OXFORDSHIRE COUNTY COUNCIL'S RESPONSE TO CONSULTATION ON THE FOLLOWING DEVELOPMENT PROPOSAL

Application no: 21/03177/F

Proposal: Axis J9 Phase 3 Howes Lane Bicester

Transport Development Control

Drawing No. 20019 - TP - 023 Rev. -

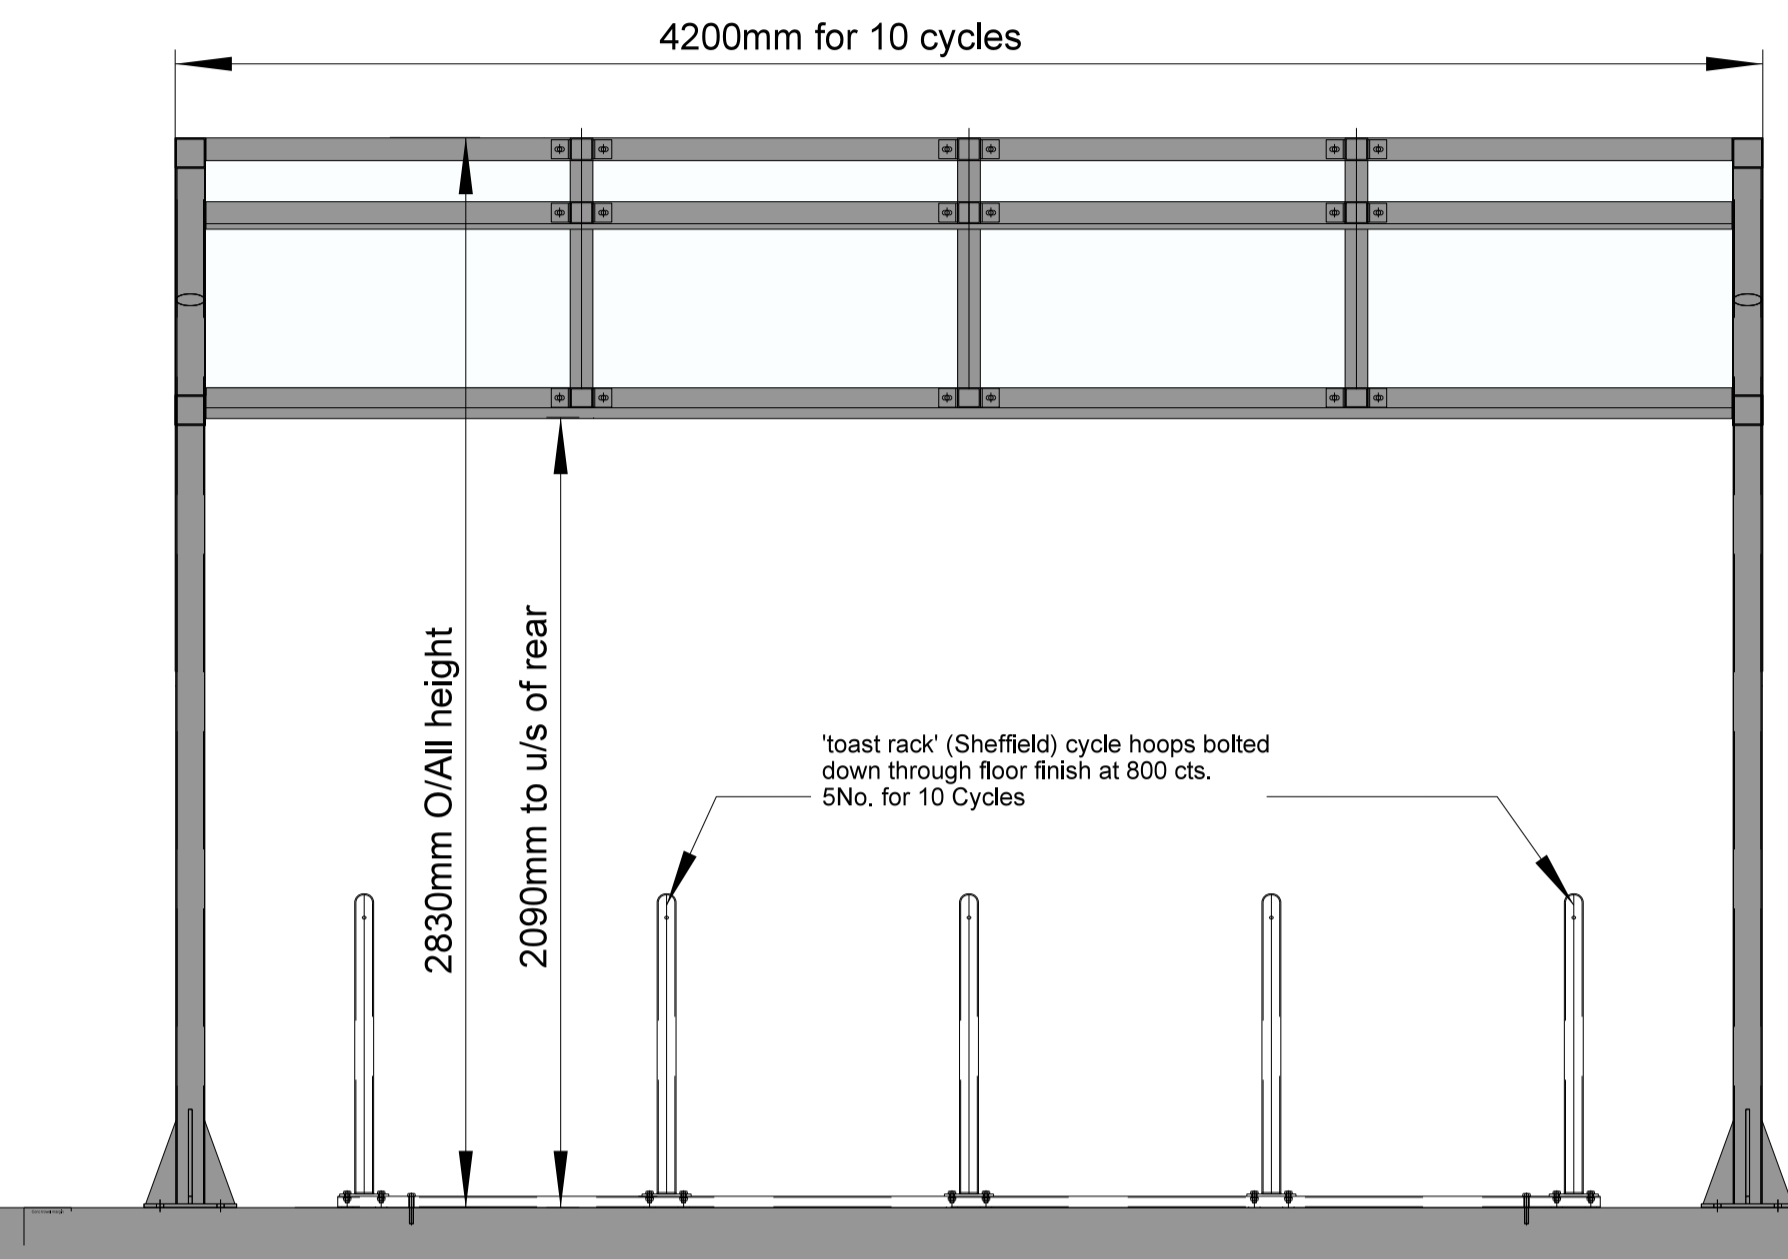
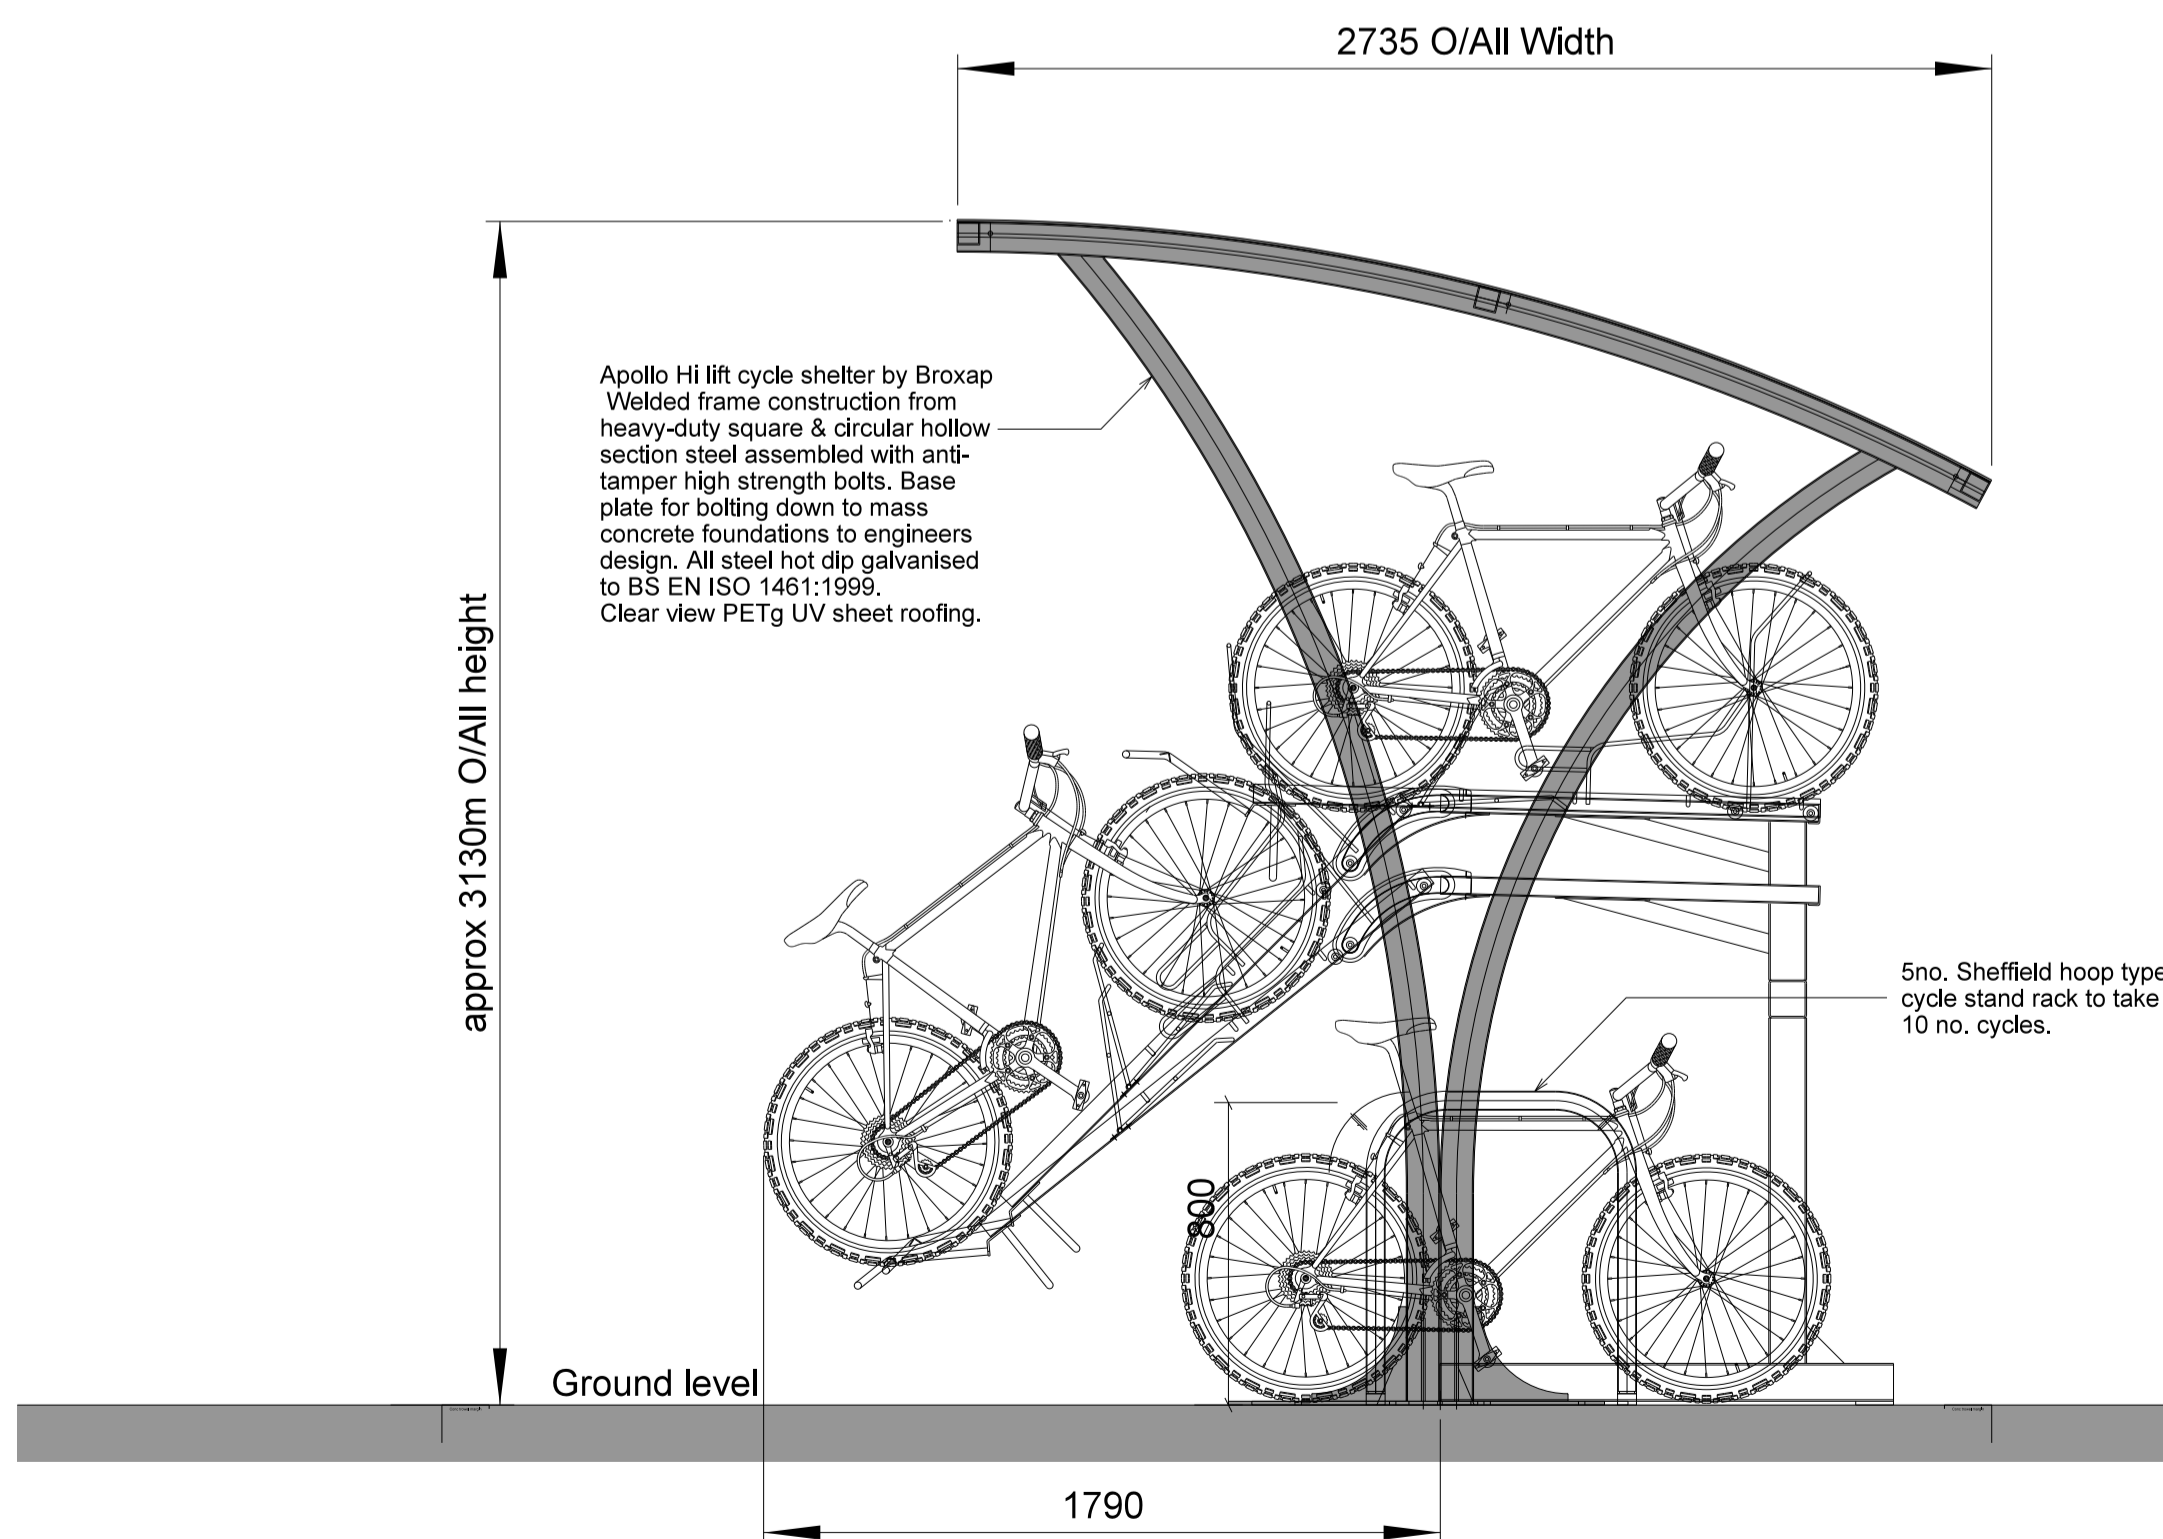
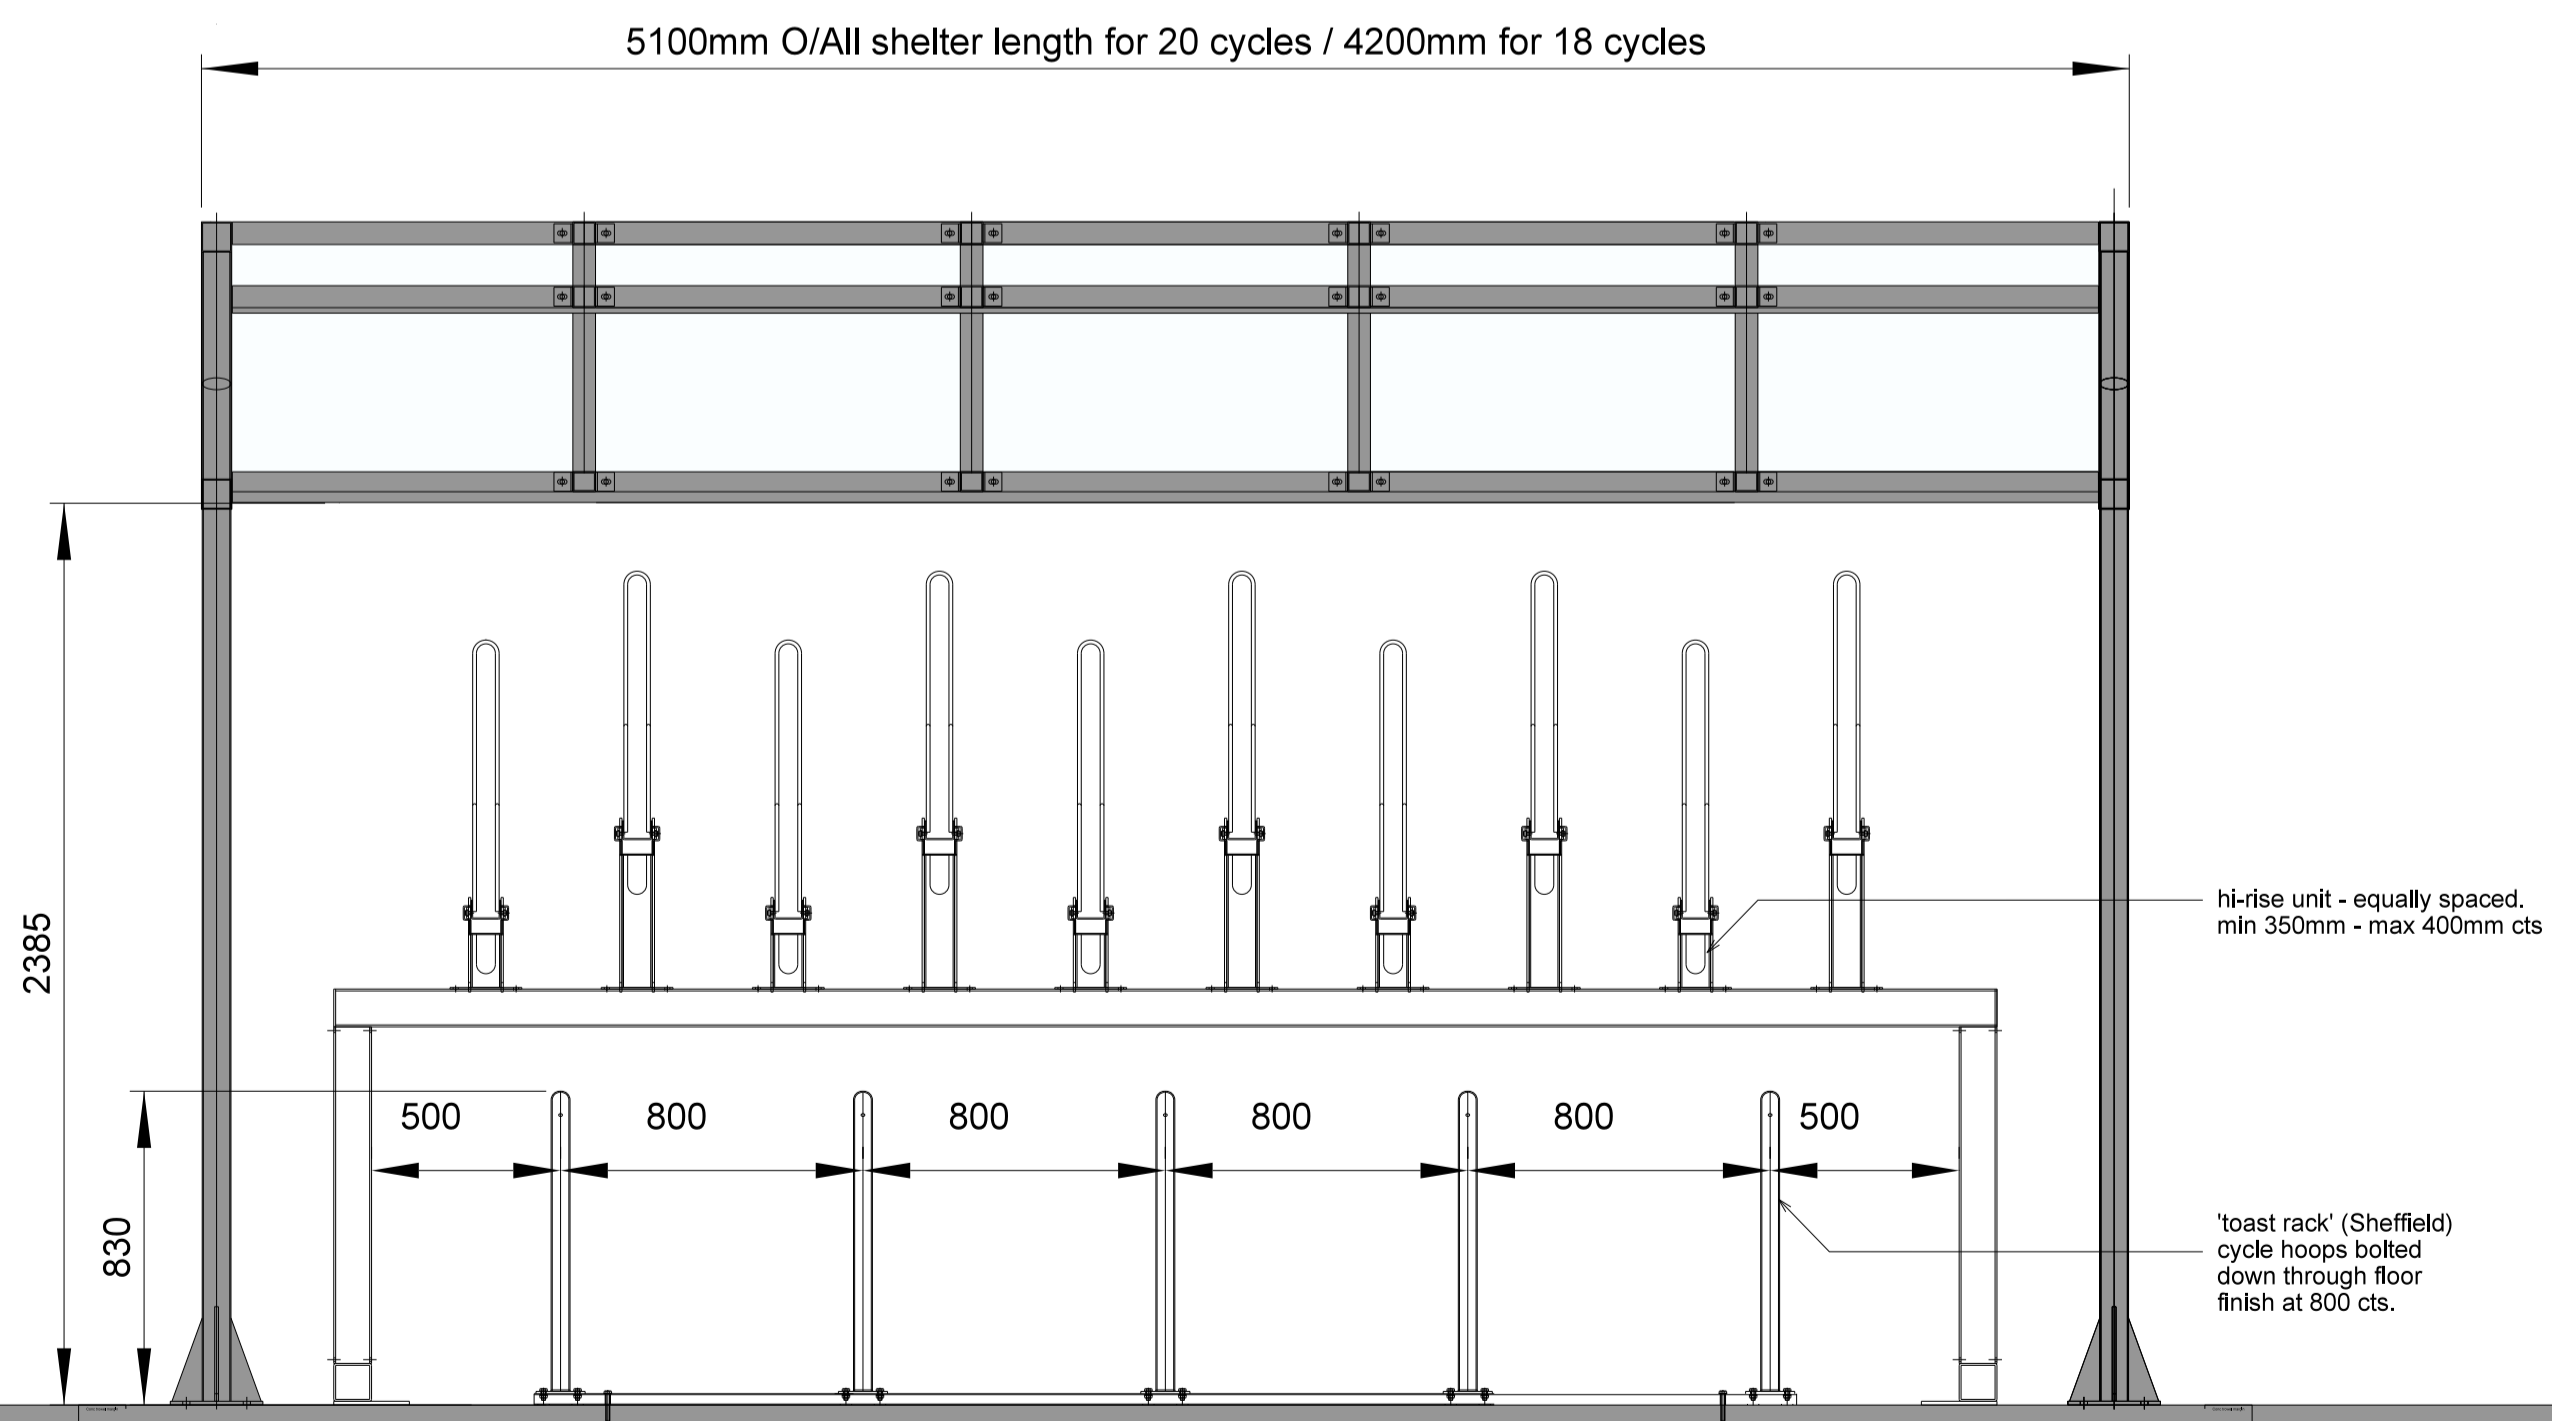
Cycle parking – on the basis of the spaces shown for cycle shelters, it looks as though 35 spaces would be provided across the whole site. Allowing for the same balance of B2 and B8 that would result in the proposed number of car parking spaces, and allowing for visitors, this would be well below the recommended number. On the basis that this development would be part of an eco town, this is poor provision and should be increased. Also the cycle parking should be positioned close to the access doors, to give this priority as well as maximum security from overlooking. In some of the buildings the cycle parking appears to be in the HGV area, which is not acceptable. The recommended amounts are shown below.

Cycle parking - requiring provision of secure, covered parking for an agreed number of spaces for each building/phase, to be provided prior to first occupation of each building/phase. Further discussion with OCC is recommended.
